Your Ref: OWPC24057
Our Ref: CM/33/19/PL 30-05-2019
Please ask for:
Mrs A Gardner

Demolition of 1 No. existing dwelling & erection of 1 No. new dwelling.

Atherington Lodge Climping Street Climping

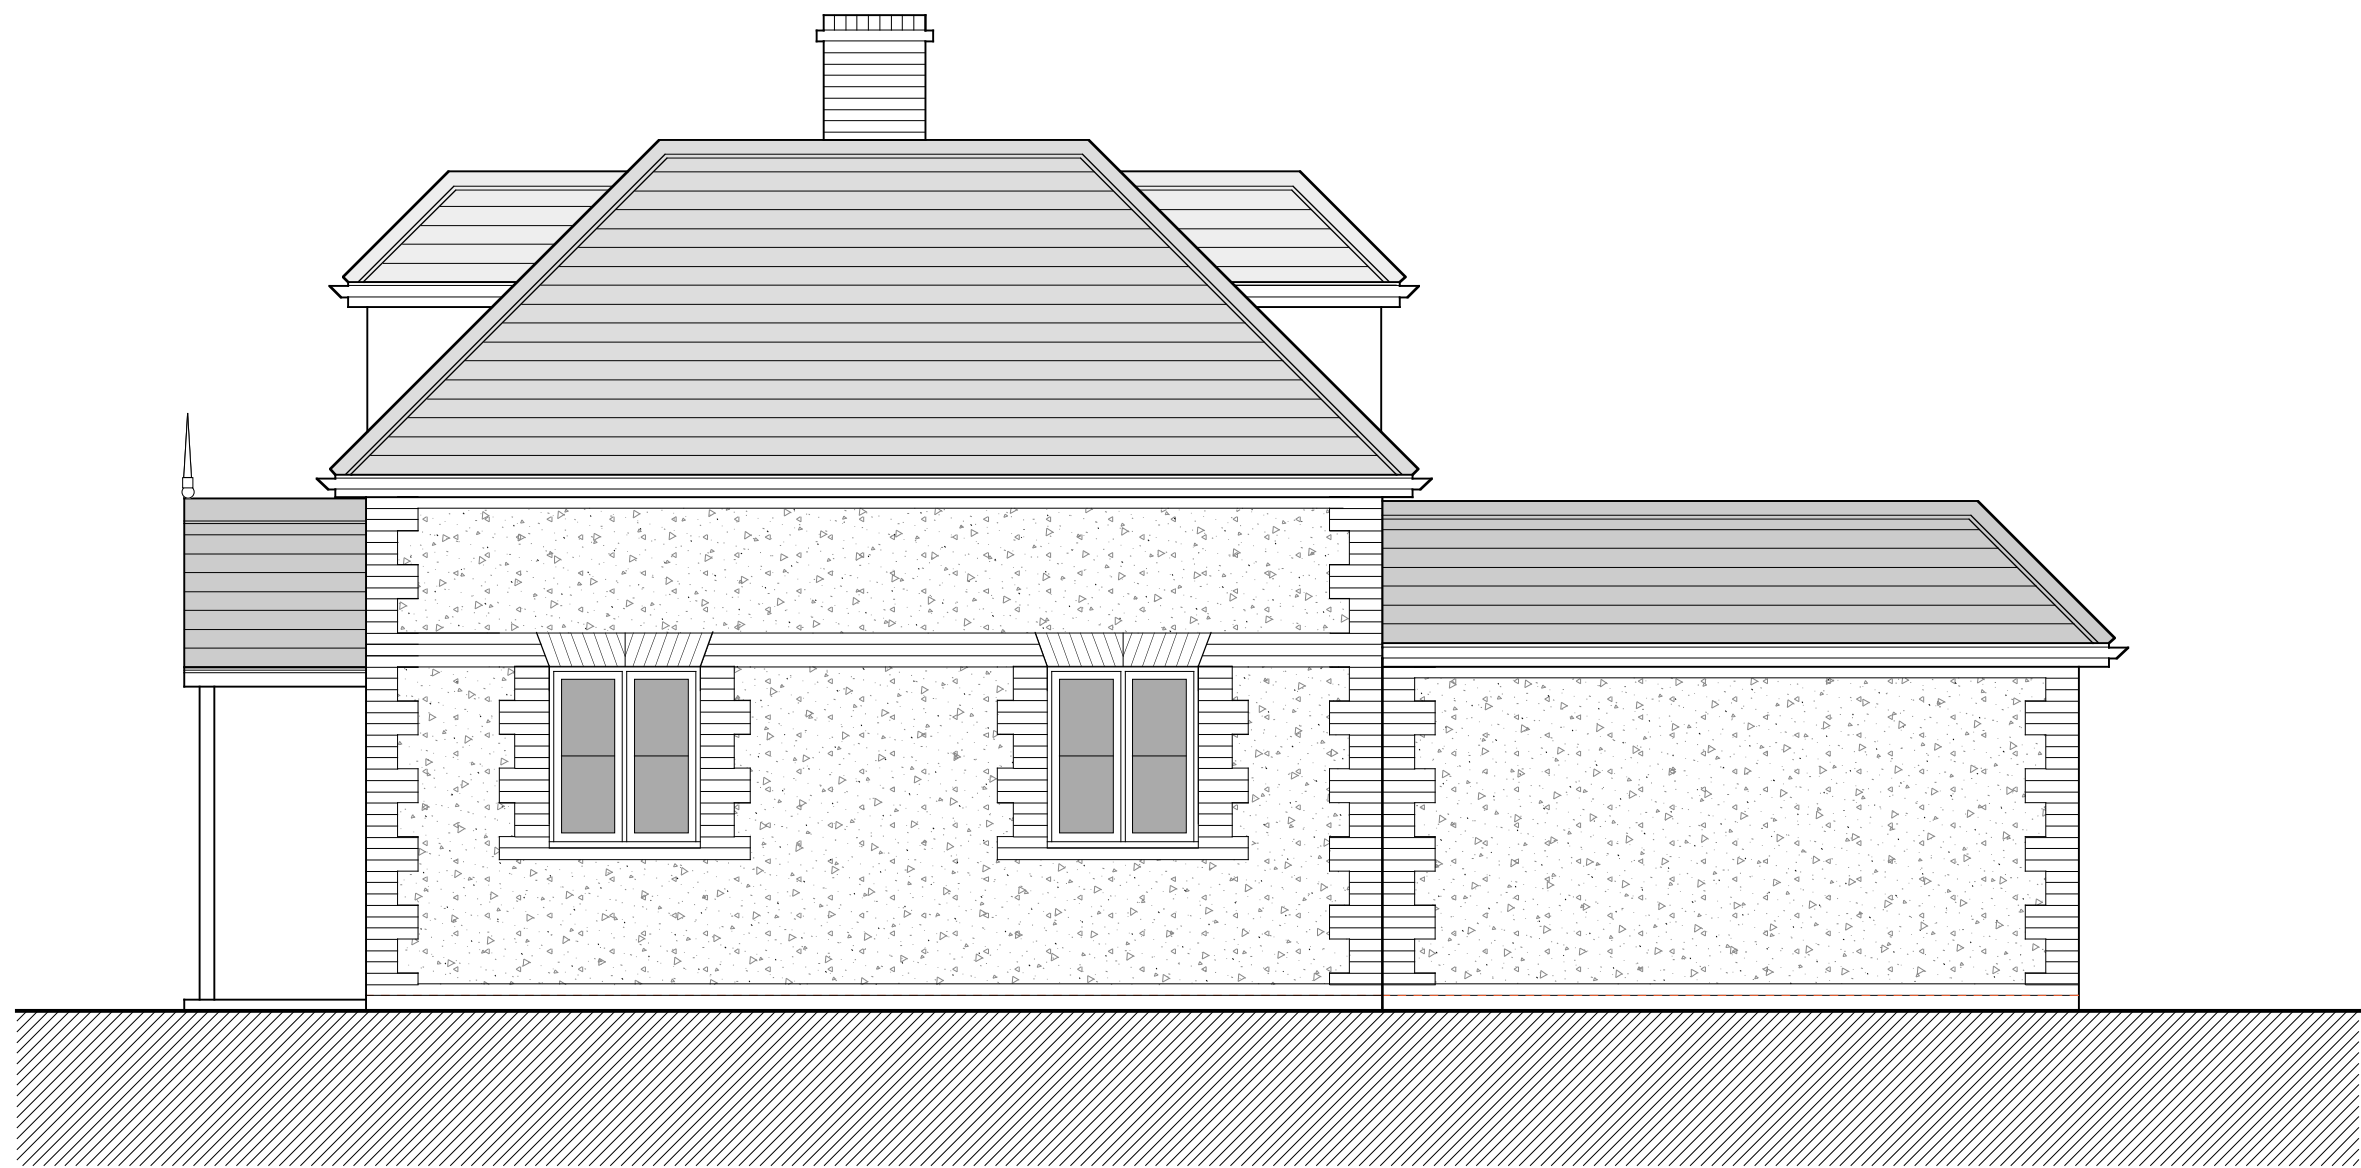
We are neighbours and his dormer windows on the West side of his proposed house totally overlook our buildings. The previous old building did not have these on this side and I strongly object to their presence. Without Planning this building is now having these dormers installed.
